Application for a non-material amendment following a grant of planning permission.

Number	
Suffix	
Property name	The Tap And Barrel
Address line 1	Duke Street
Address line 2	
Address line 3	
Town/city	Littlehampton
Postcode	BN17 6EU
Description of site location must be completed if postcode is not known:	
Easting (x)	502787
Northing (y)	102172
Description

Retention & conversion of former Public House building & the erection of two storey block to provide a total of 9 No. residential units with associated parking. Re-submission of planning application LU/117/17/PL	
Reference number:	LU/364/17/PL
Date of decision	25/01/2018

6. Non-Material Amendment(s) Sought

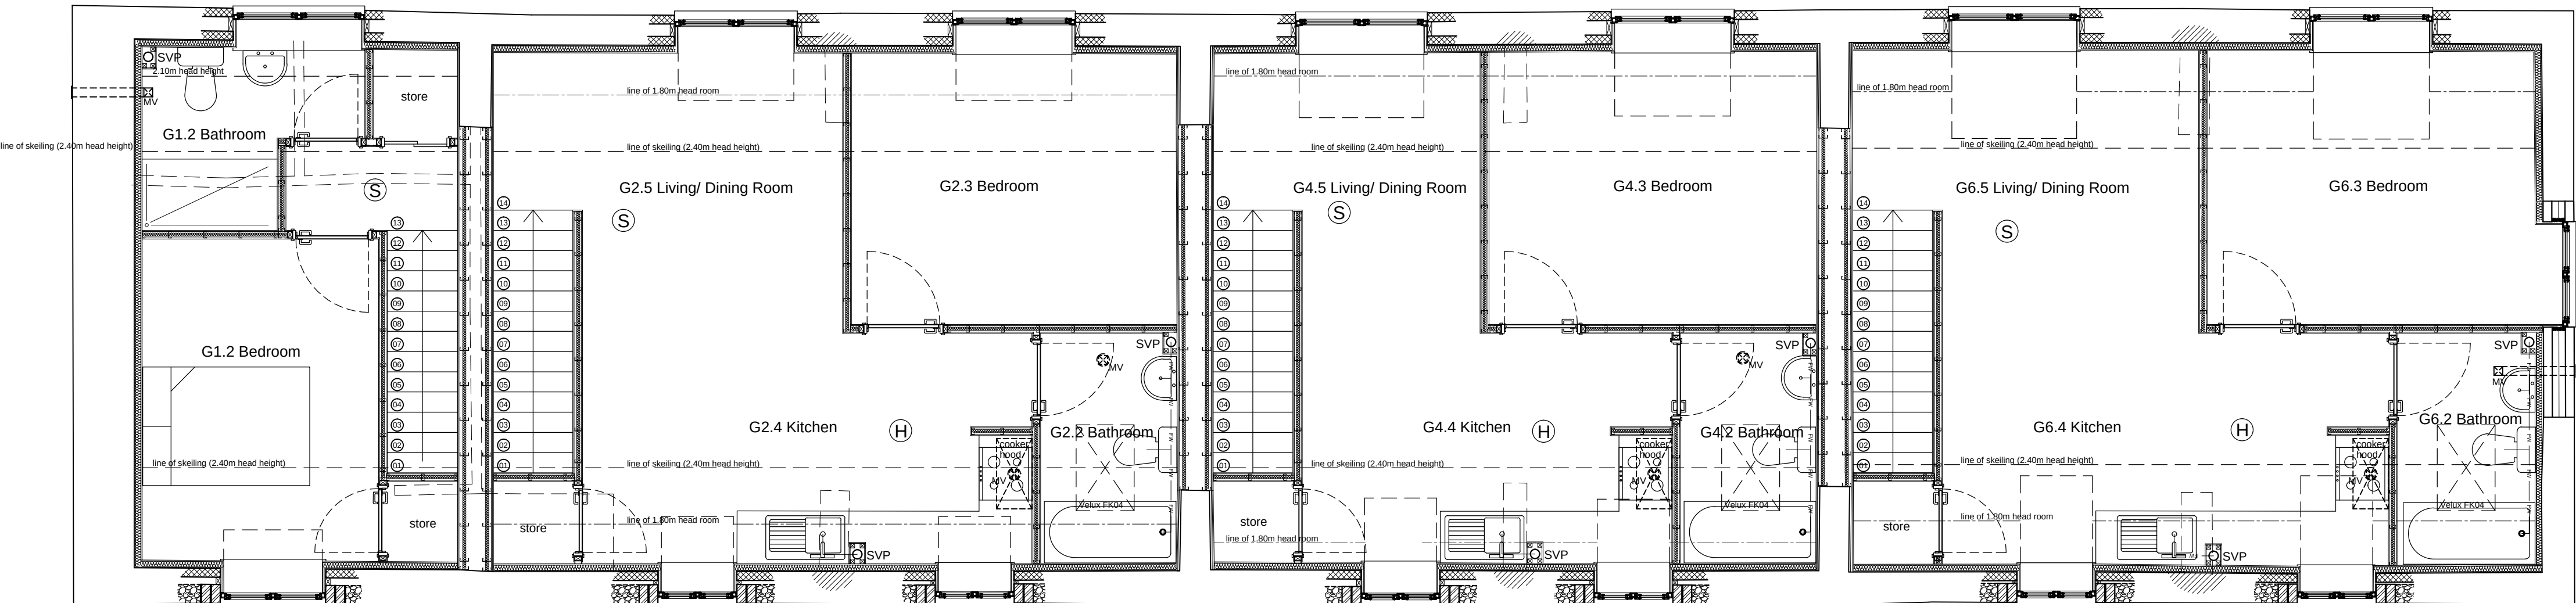
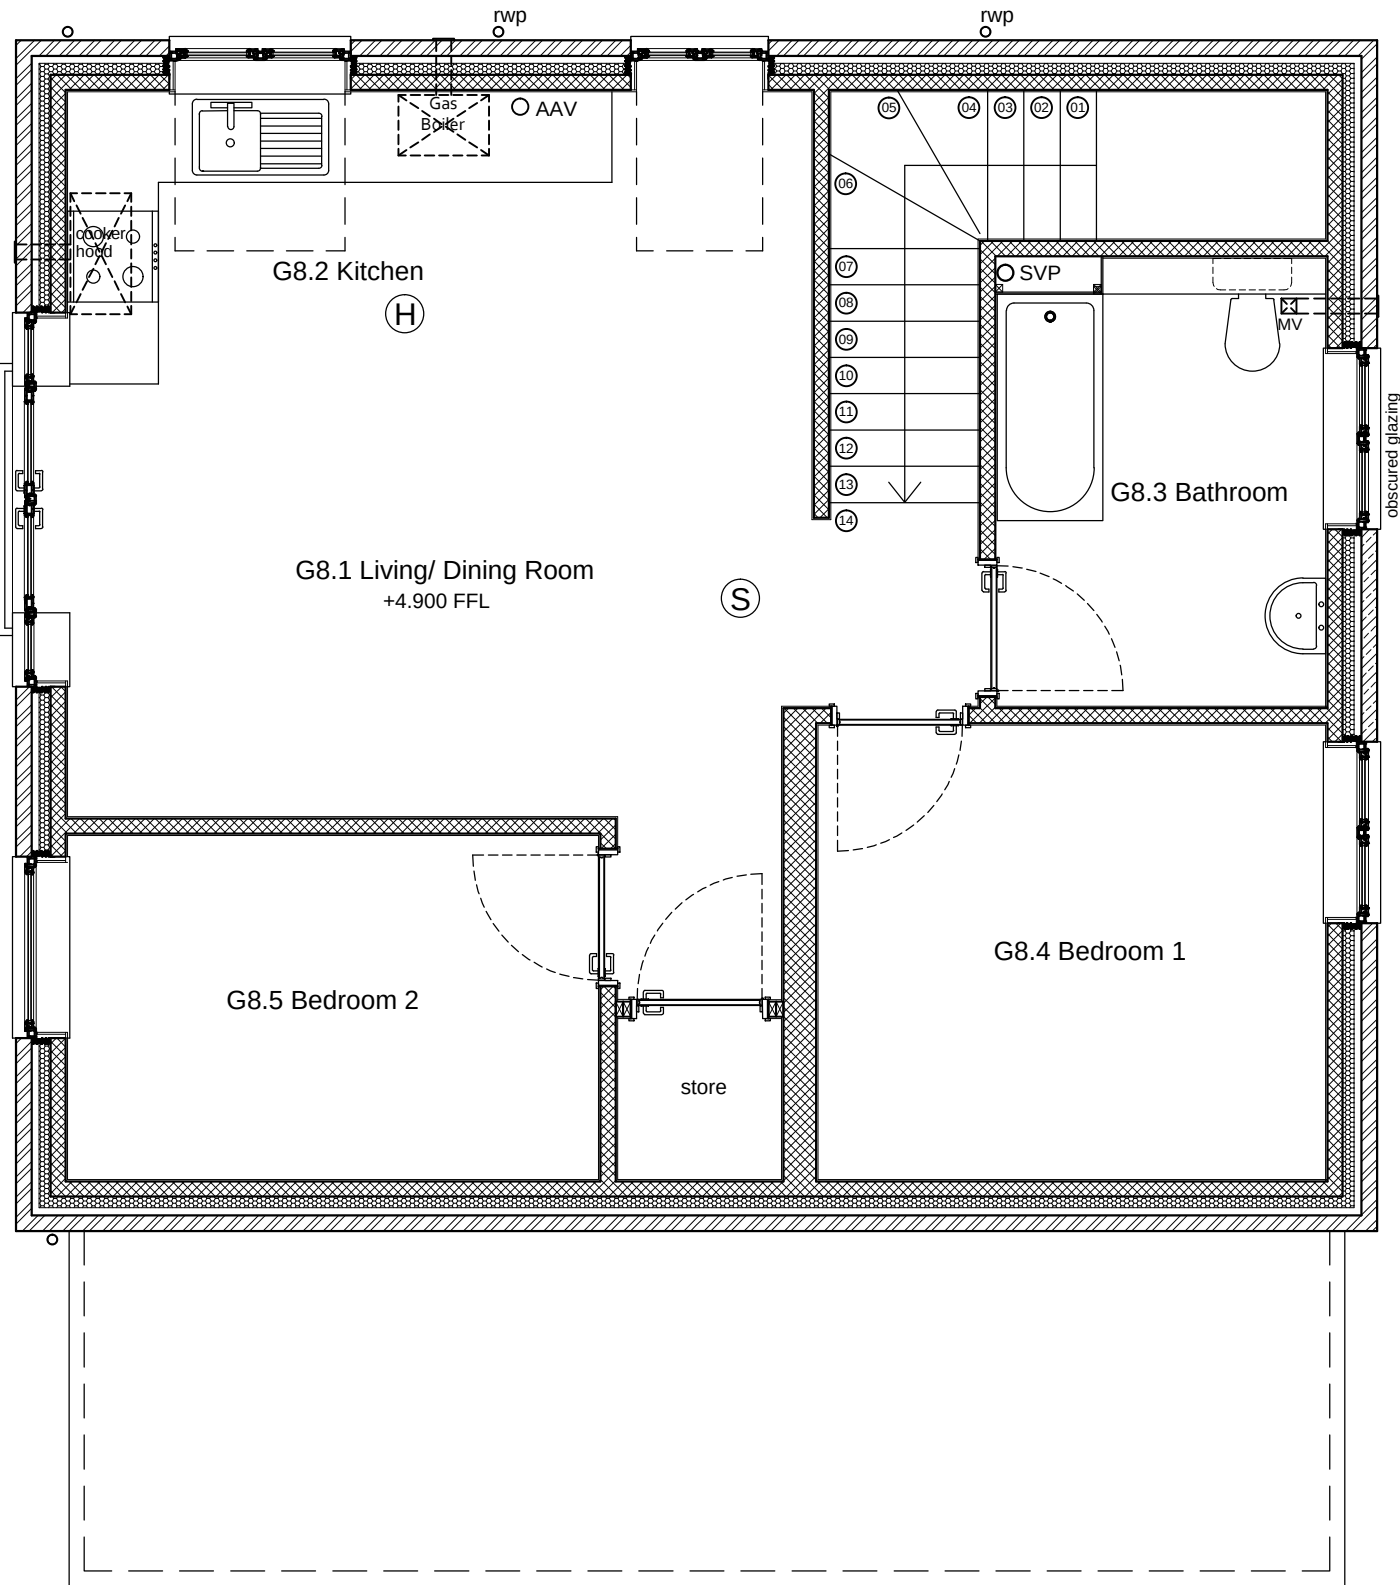
- omission of balconies to flats;
- amendment of material specification of lead dormers to GRP dormers
- position of glazed double door & sidelights and window to the northern elevation of the new build flats have been mirrored to reflect alterations in floor plan layout
- window and dormer width to western elevation of new build flats to kitchen amended to reflect alterations to floor plan layout
- window head & cill heights, and therefore dormer roof heights amended to Eastern & Western Elevations to the converted building to accommodate detailed design
- window width to eastern elevation to flat 1 amended to suit existing opening width
